Applicant: Mrs I Wainwright

Description: Replacement of garage doors (Planning Application and & Listed Building Consent)

Site Address: The Granary, 3 Fieldhead Manor, Elmhirst Lane, Dodworth, Barnsley, S75 4LD

GARAGE DOOR SPECIFICATION

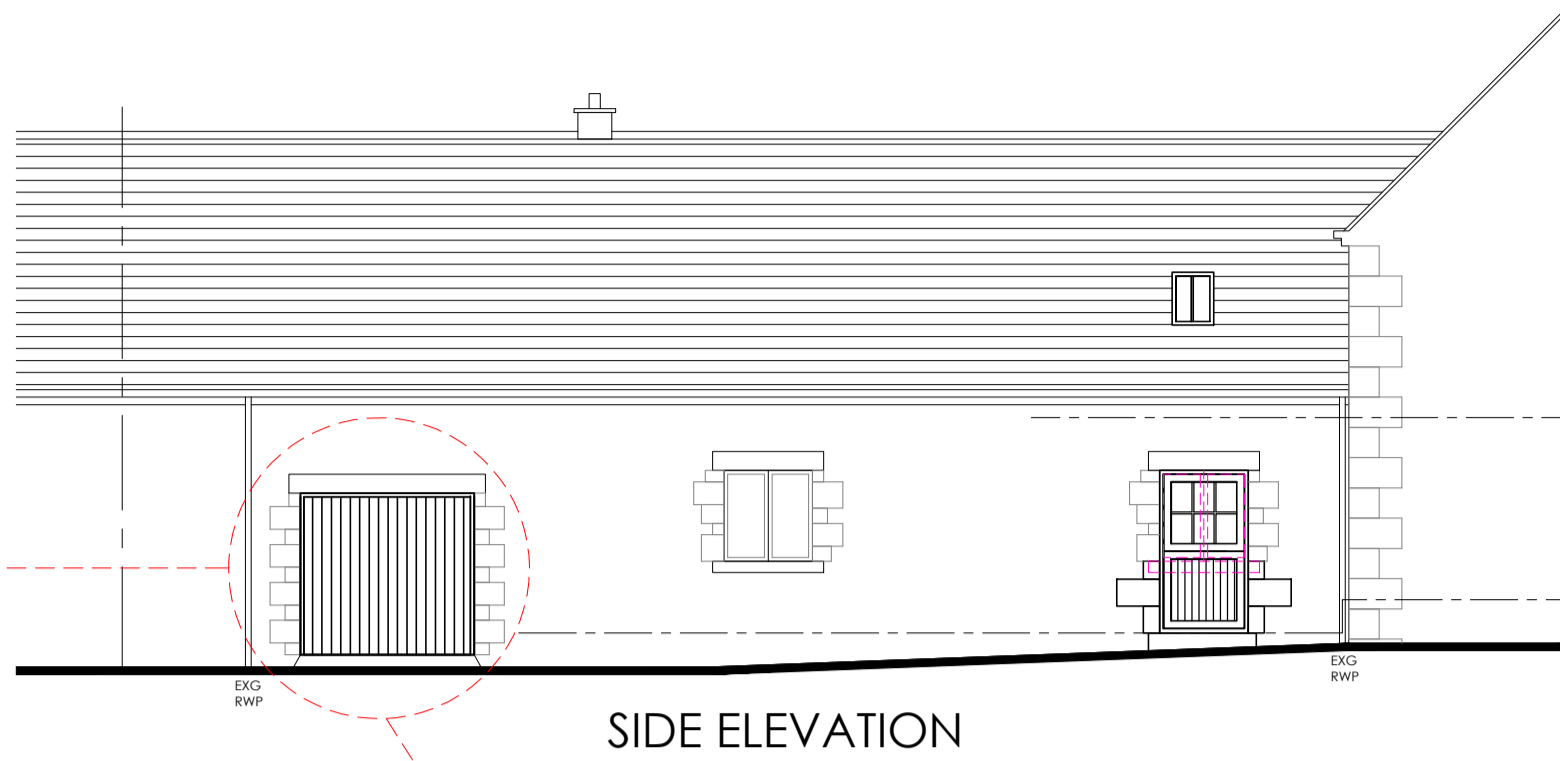
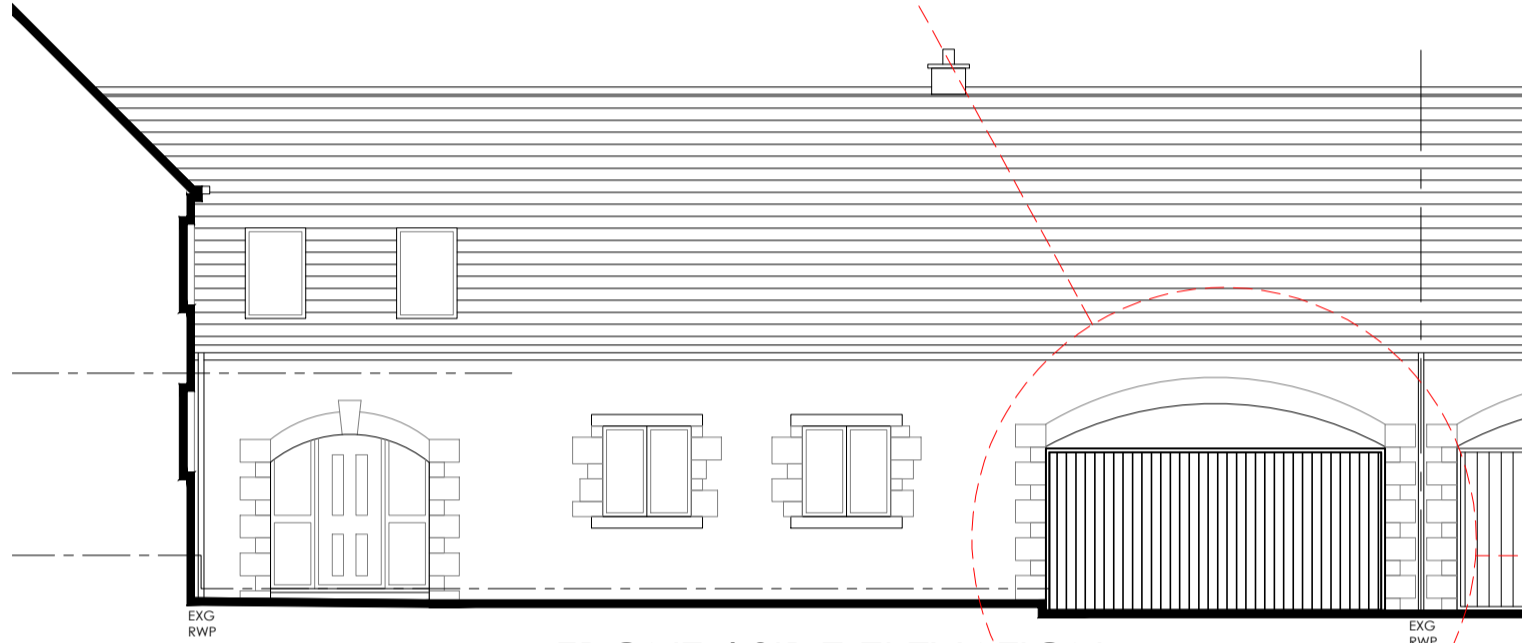
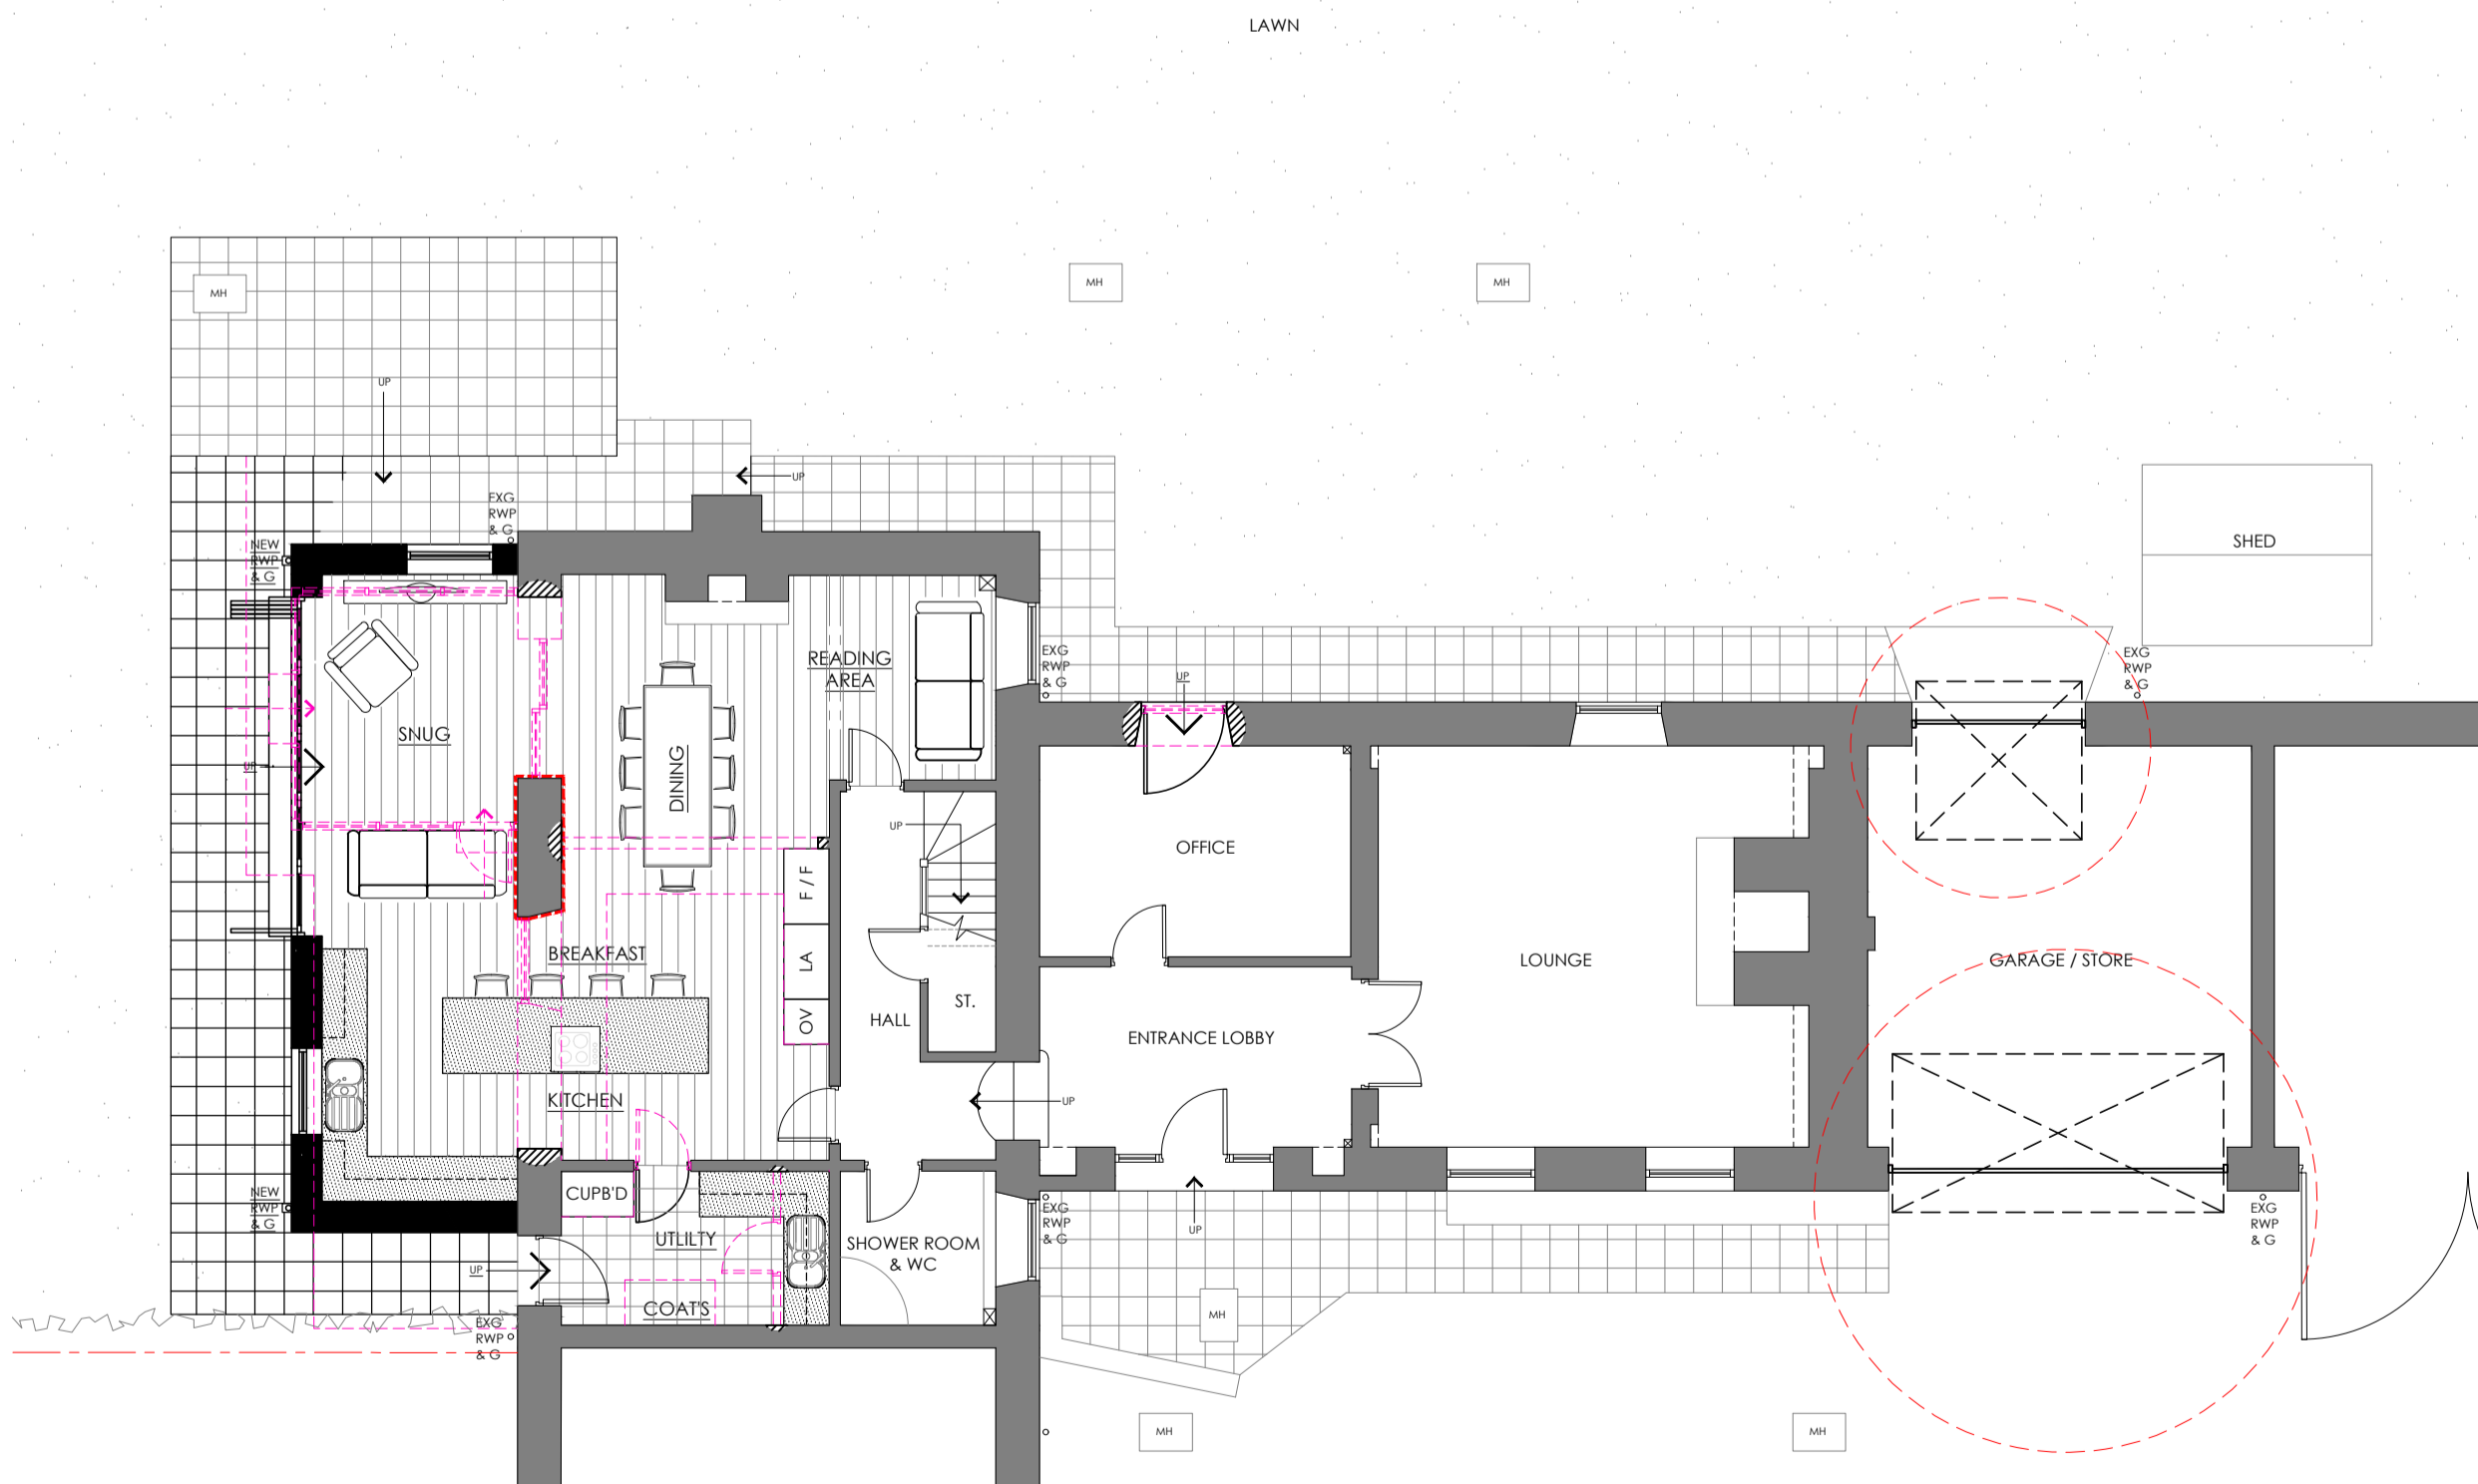
The Conservation Officer did question the colour of the doors which was labelled as Agate Grey on the submitted drawing. However, the applicant has since stated that the doors will be finished in Oak decoration to match the utility door and study door approved under planning application/Listed Building Consent 2020/1455 & 2020/1460
